Our Ref: BR/337/19/HH

8th January 2020

**Town & Country Planning Act 1990 (as amended)
Town & Country Planning (Development Management Procedure) (England) Order 2015
Application for Householder Planning Permission**

Development Change of use from open space living room to 1 No. bedsit or studio with separate entrance
Location 128 Collyer Avenue Bognor Regis

PROPOSED
BR/337/19/HH

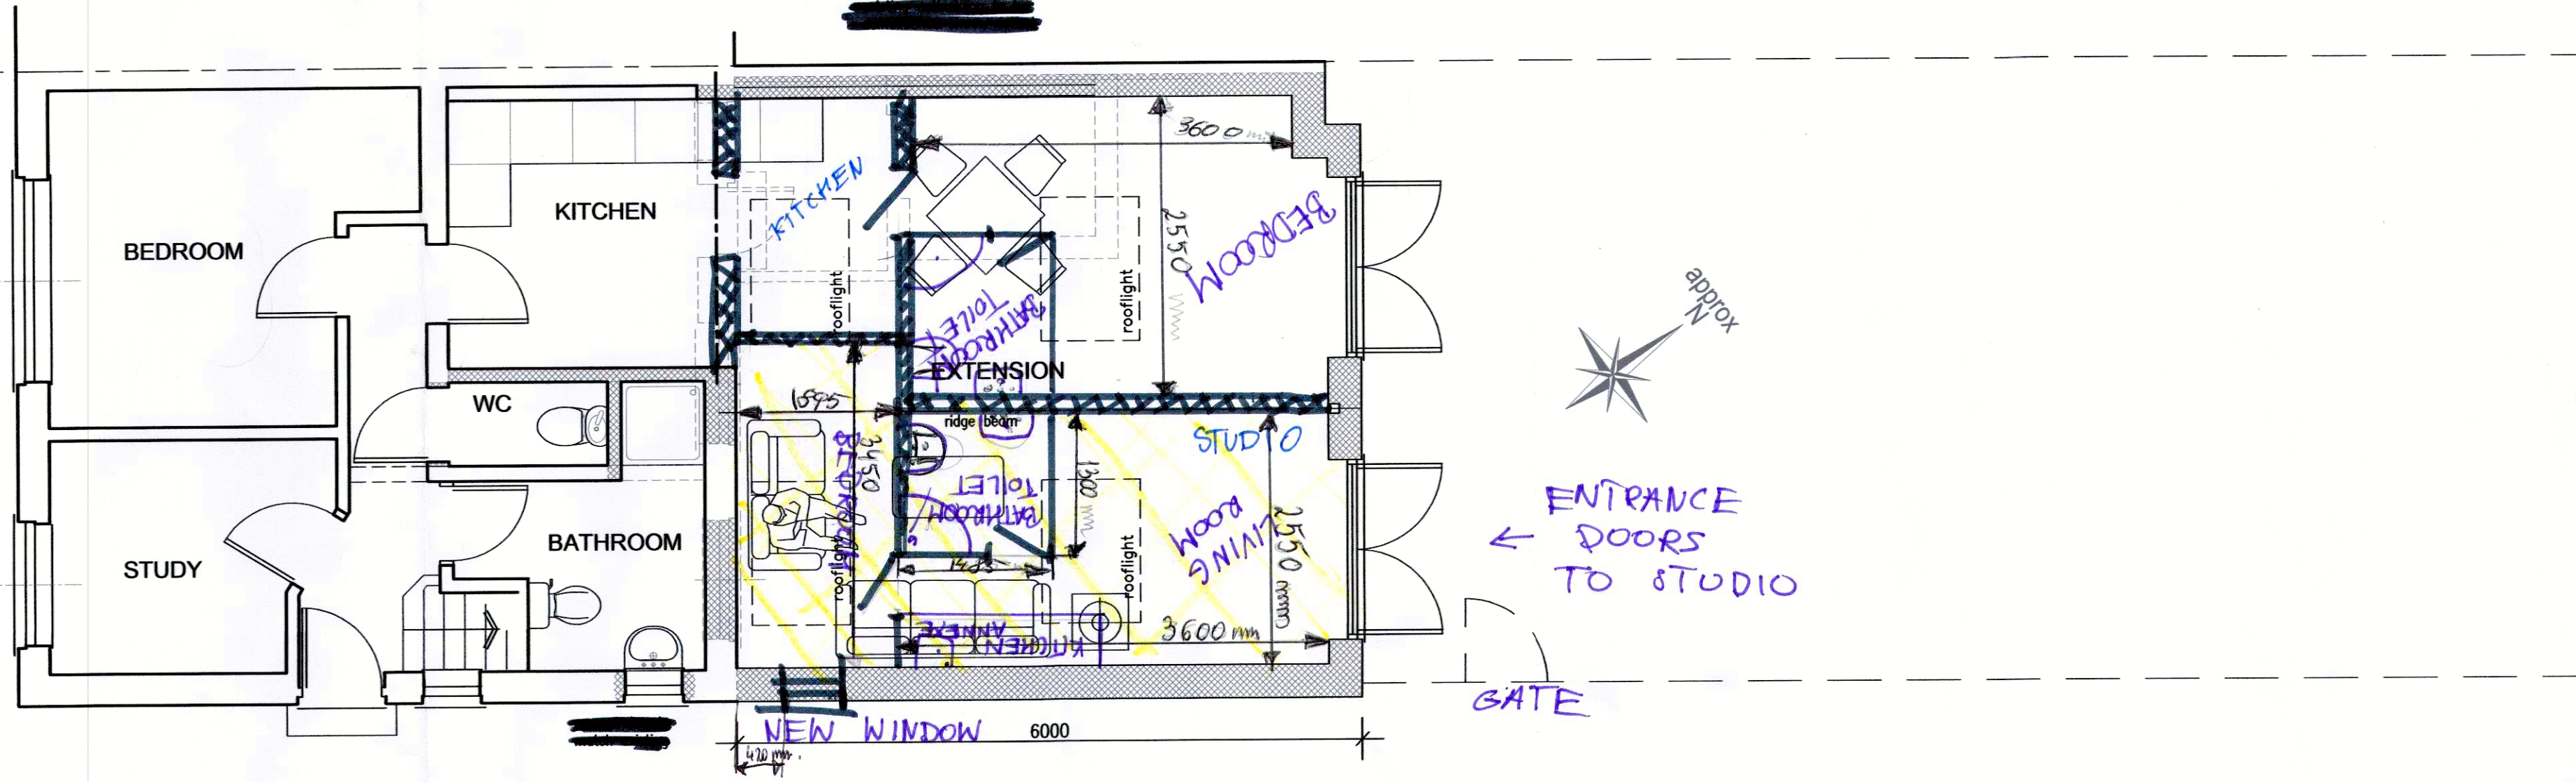
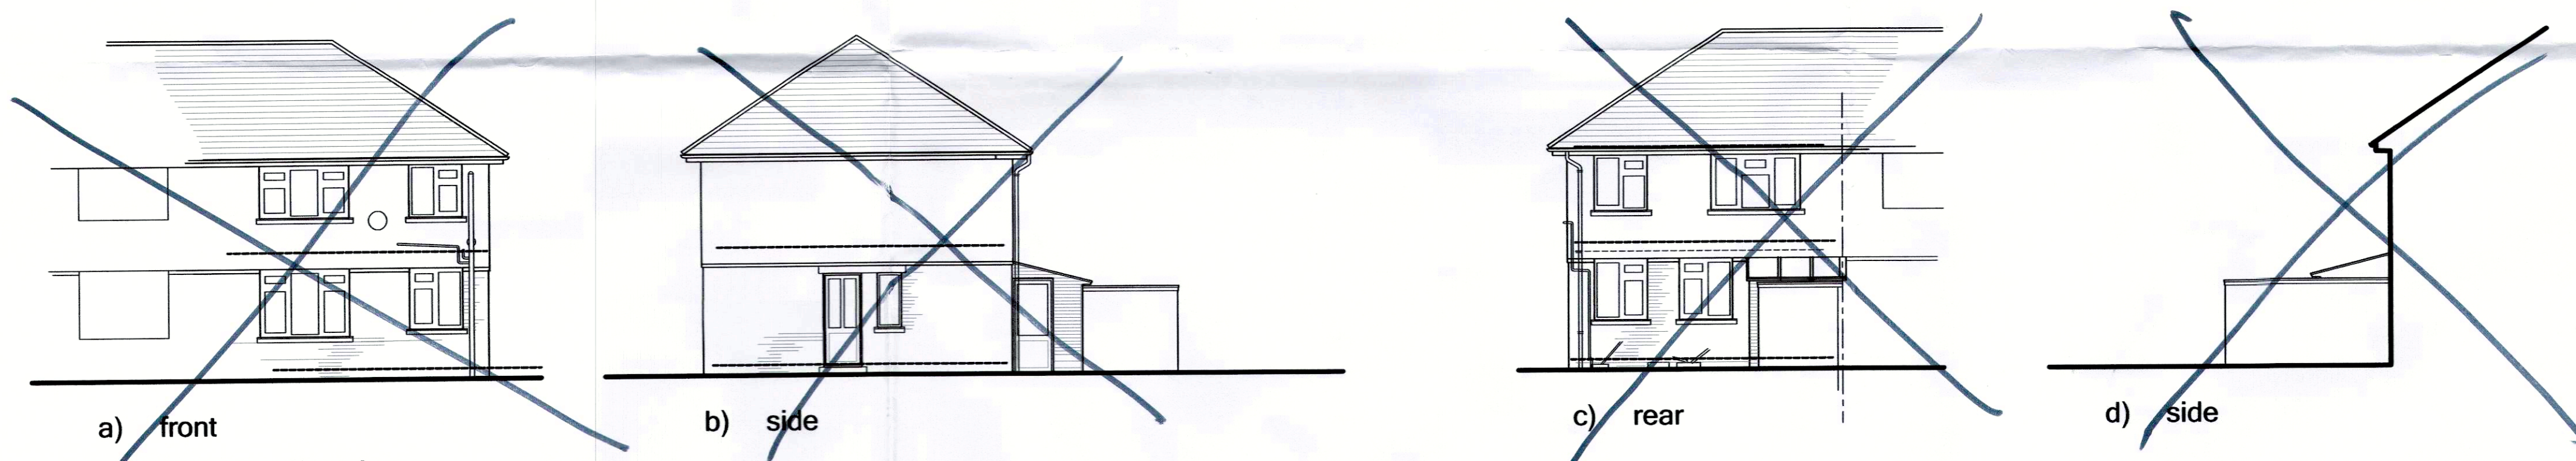
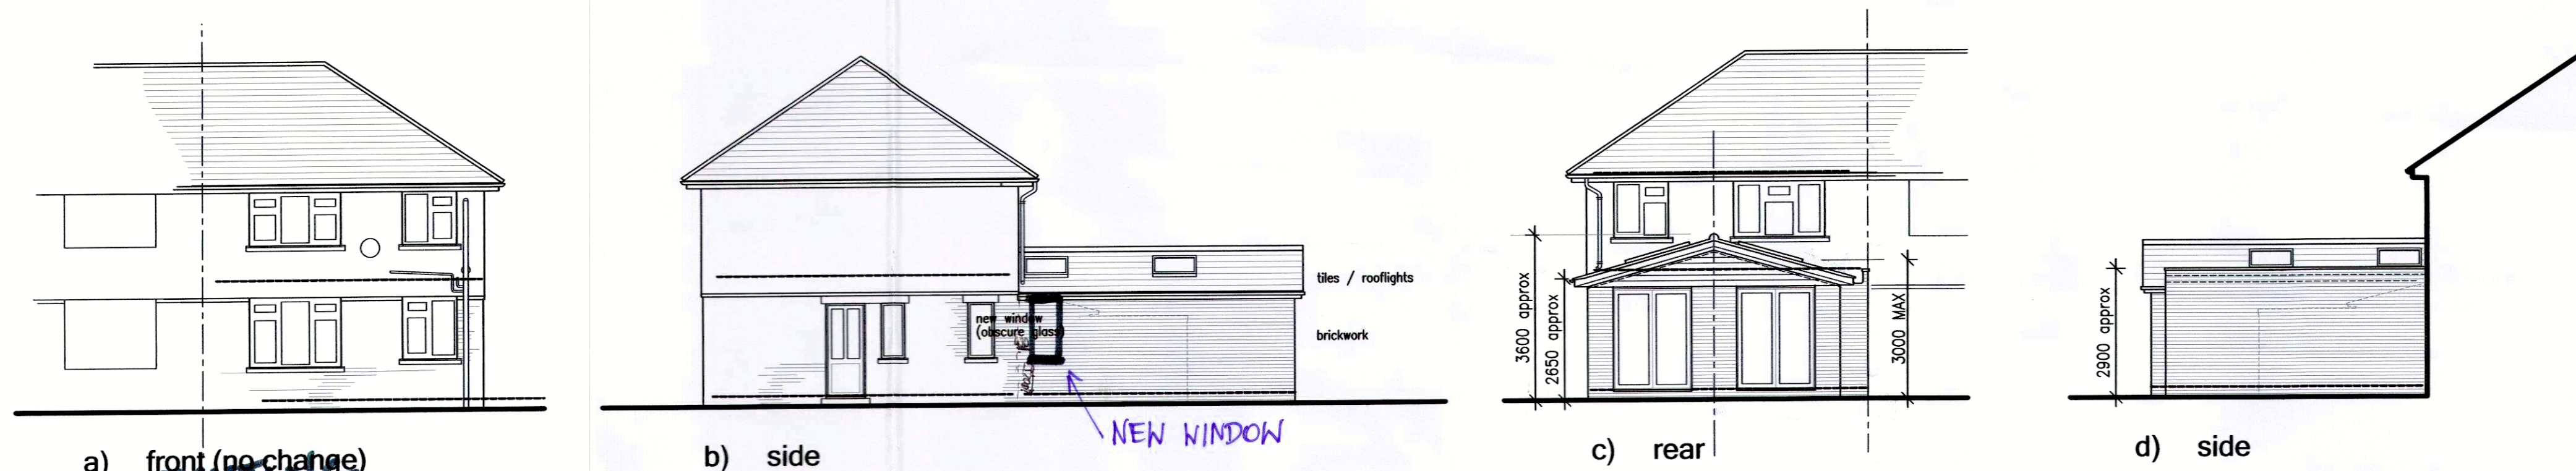
The plan labelled proposed has also been labelled existing at the bottom of the page. Please label b) side as Proposed, and all other elevations on this sheet as Proposed - no change.
